From: Amanda Scholes on behalf of Planning.Responses
Sent: 10 February 2021 11:12
To: Planning Scanning
Subject: FW: Response To Application Number Y/131/20/DOC at Land south of Ford Lane and East of North End Road, Yapton

LAND SOUTH OF FORD LANE AND EAST OF NORTH END ROAD, YAPTON

The consultation requiring comments in response to the PRow and the cycleway across the site and the connections to Ford Lane should be under **Condition 8** of discharge of condition application **Y/131/20/DOC**.

Drawing Title
Sections through public right of way footpath 357

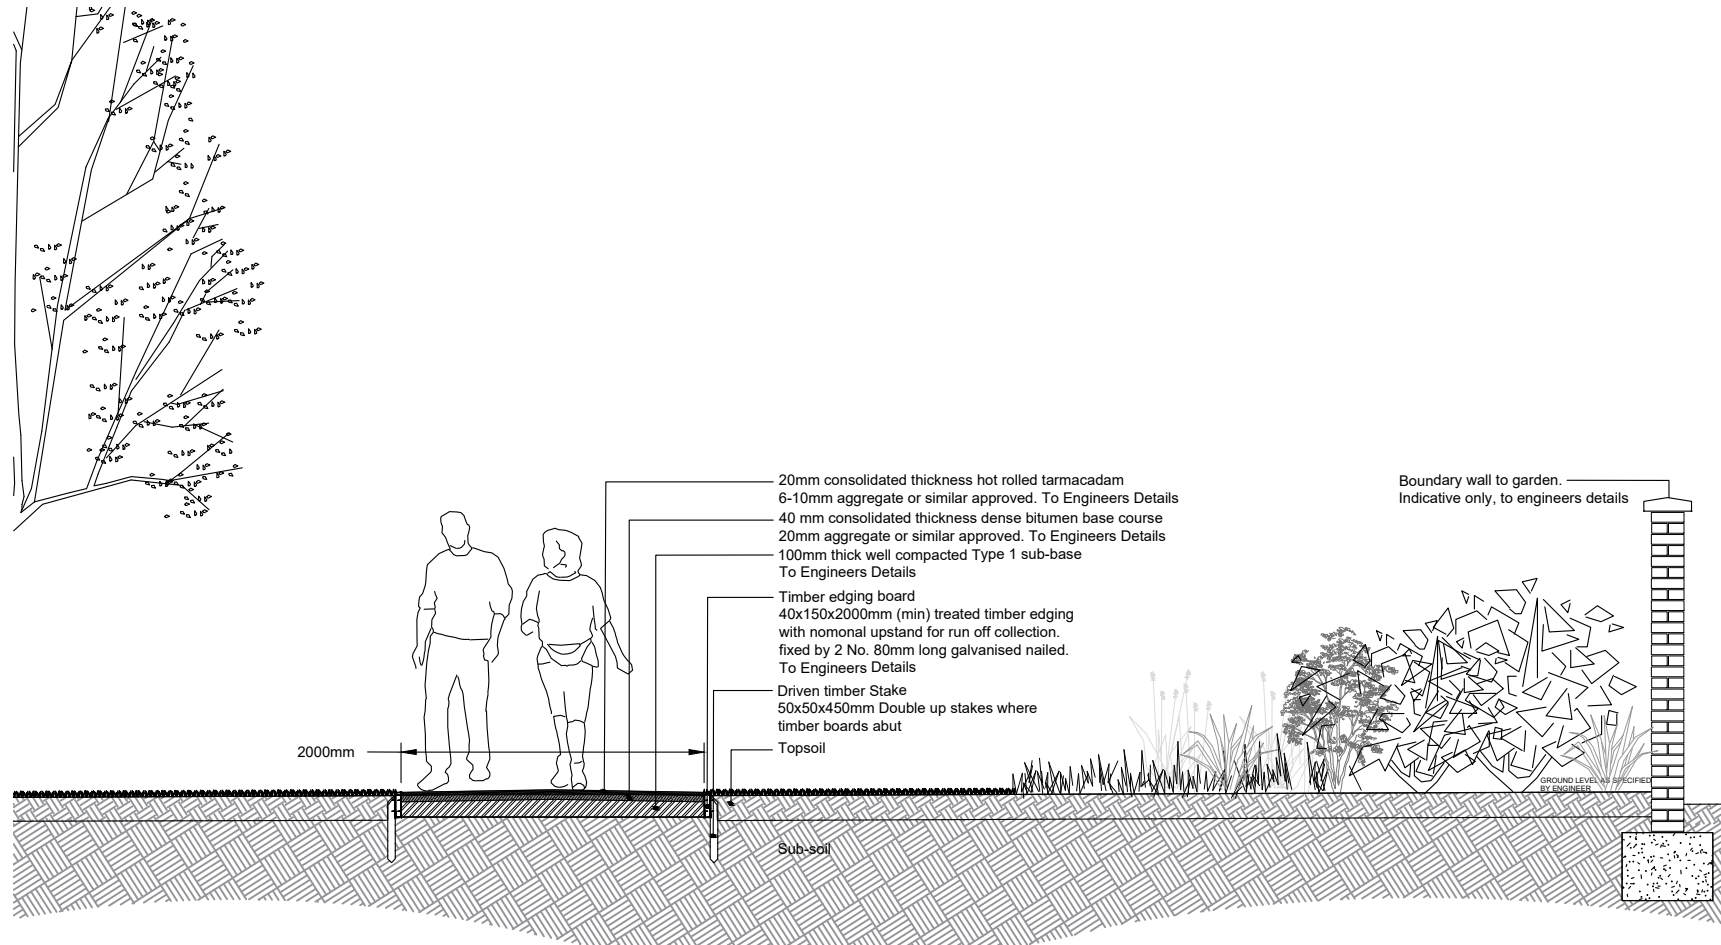
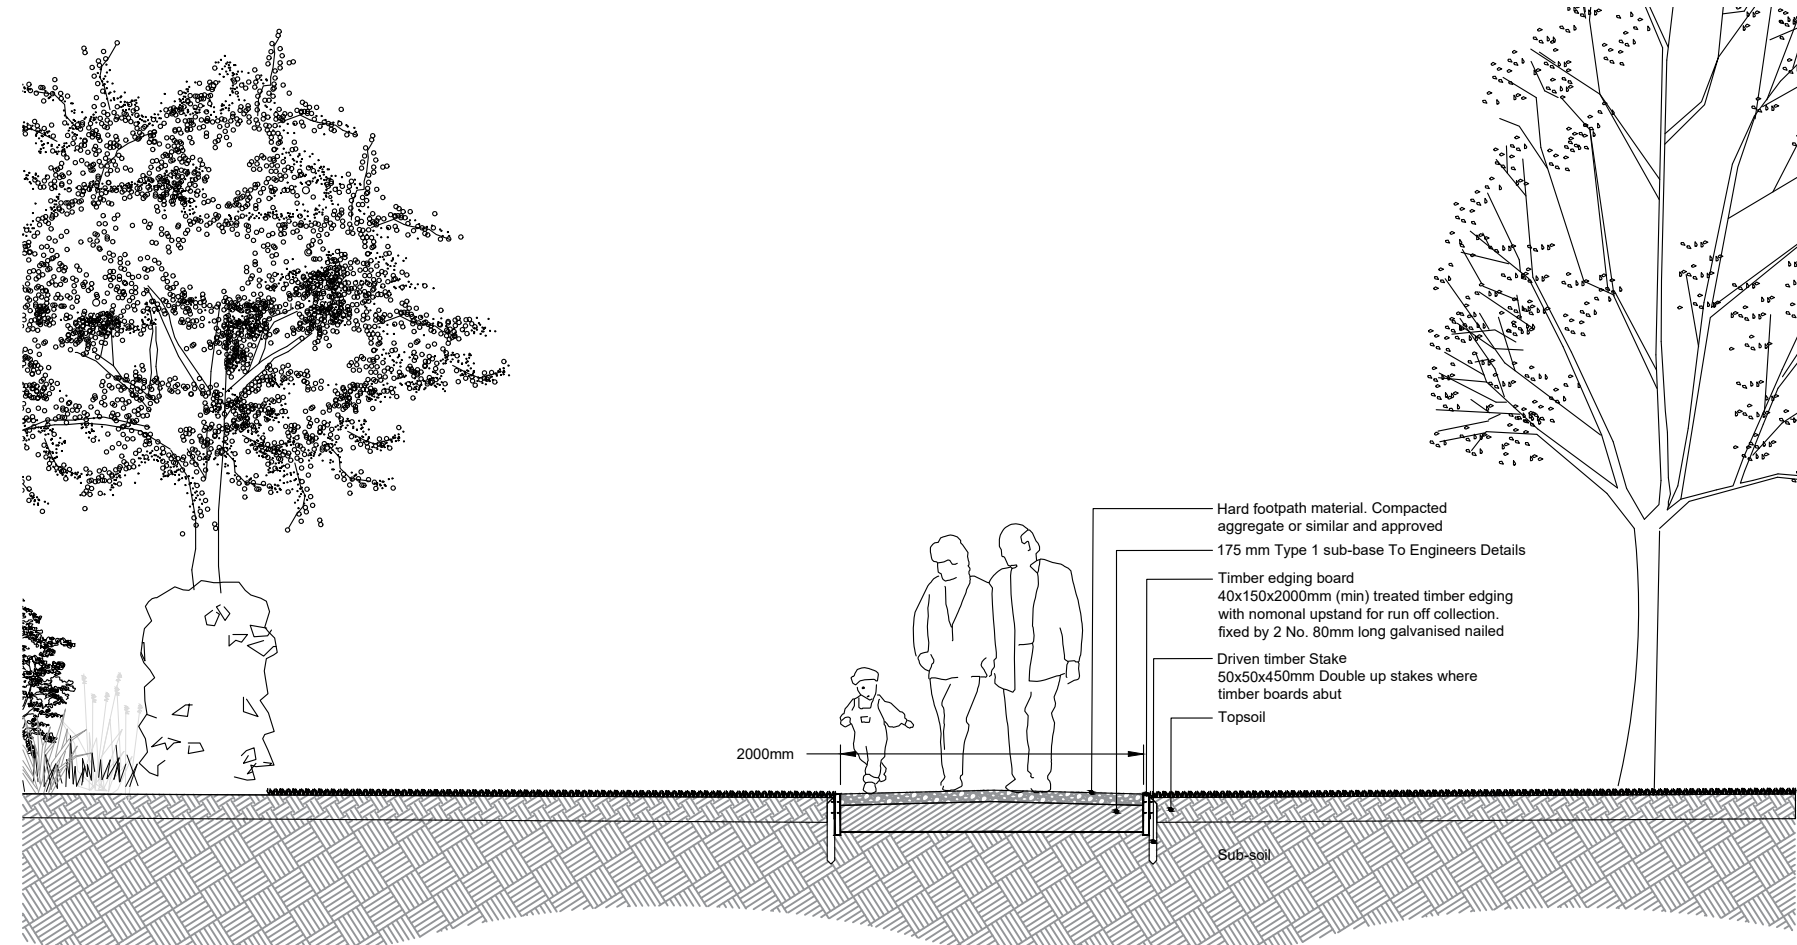
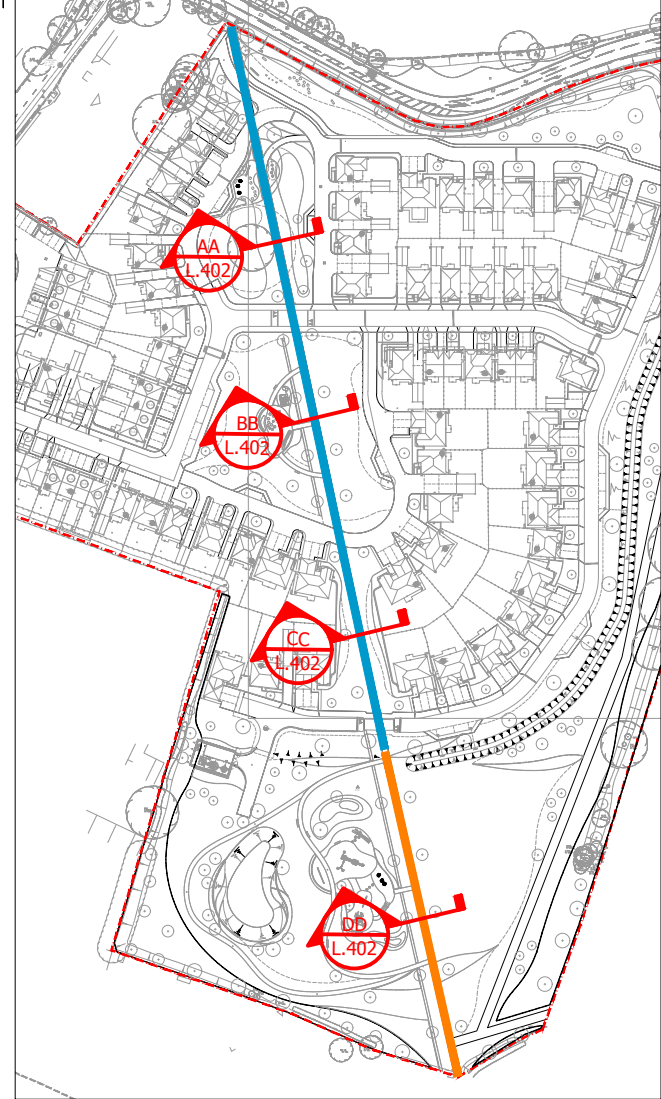
From a PRoW perspective we are now seeking to maintain the current arrangement for the Footpaths, albeit achieving a 3m width and surfaced to the supplied specification, to future proof the options here. The cycleway West to East may feed into the footpath along the Eastern boundary however primarily this is a matter for the Planning Authority and developer to discuss with regards to improved links and may well feed into any future plans for development on the adjacent site, so I acknowledge its merits.

The developer may decide, on an informal basis, to allow cycling on the Footpaths within its land ownership but as above this may not be formally advised on either Footpath 357 or 358 as no legal agreement to change the status is currently being sought. Other than the staggered barriers under discussion at the Ford Lane junction of Footpath 358, no other structures will be permitted on the surface of the Public Footpaths without formal application.

Movement Plan

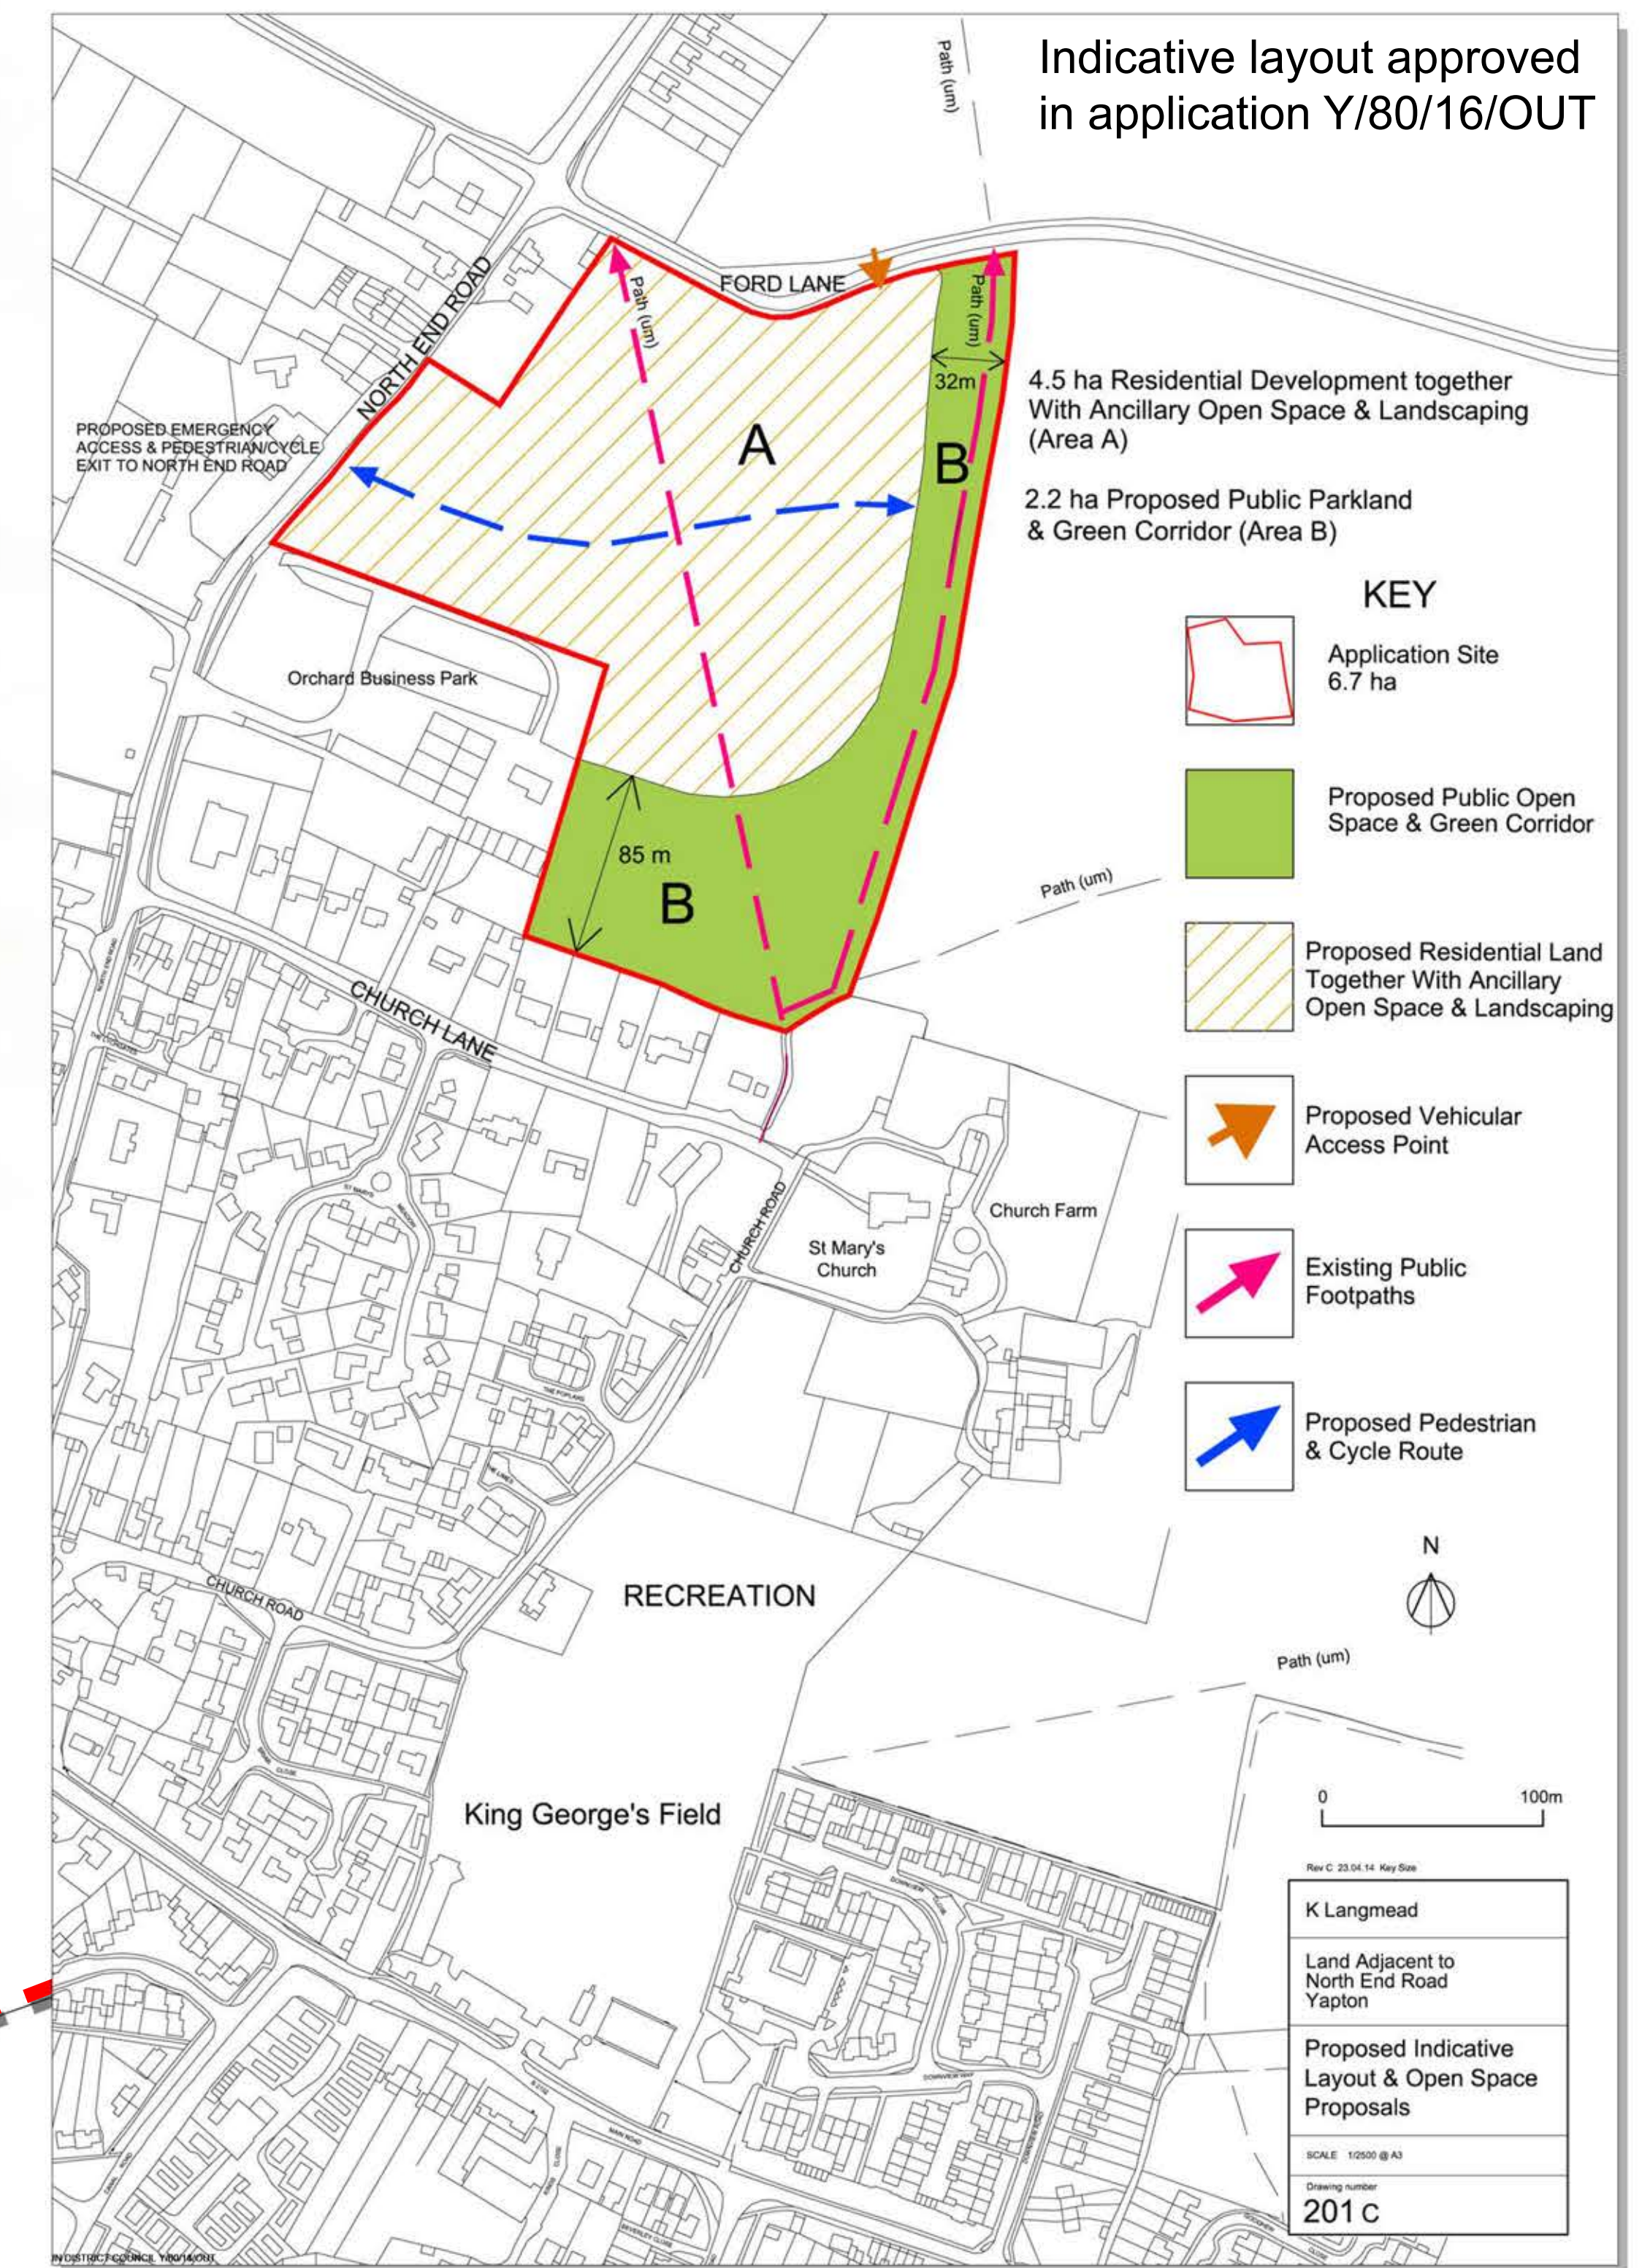
The Local Planning Authority has concerns about the locations of the 2 proposed cycleway crossings identified on the Cycle Route Plan that are located east of the swale, linking up with the adjacent field.

Do you consider there is a need for 2 cycleway crossings into the field to the east of the site, or would 1 cycleway crossing be sufficient?

Should the cycleway crossing(s) line up with the crossing point over the swale so that cyclists can cycle with ease and not fall off their bikes at the right angled connection with the Public Right of Way which runs northwards towards Ford Lane?

My understanding is that the applicant in their 'movement/accessibility plan' has accepted the principle of Public Footpath 357 becoming a shared foot and cycle way whereas Public Footpath 358 will be upgraded to Bridleway status. As such we would need to see the details of how they join and interact at the points they join Ford Lane and how they terminate south of the site. This will require plans from the applicant and either a further Stage 1 Road Safety Audit or Supplementary Road Safety Audit (if the latter is permitted under GG119) to ensure that any changes required as a consequence of the change of status of the paths has been properly considered. Another PRow - Public Footpath 359 - shouldn't need altering at the present time other than the developer confirming that space either side would not be encroached upon as part of this development. The reason for this is that if development comes forward to the east at some time in the future there would then be scope to upgrade this path too. Including the path, an overall width of 5.0m would be sufficient taking the path as centreline to this.

The cycleway will not be adopted or dedicated as a Public Right of Way and so my only comments would be to reiterate the need to differentiate between those routes advertised on site as cyclable and the two Public Footpaths to prevent any contradiction with the WSCC Footpath way markers which will be in place.
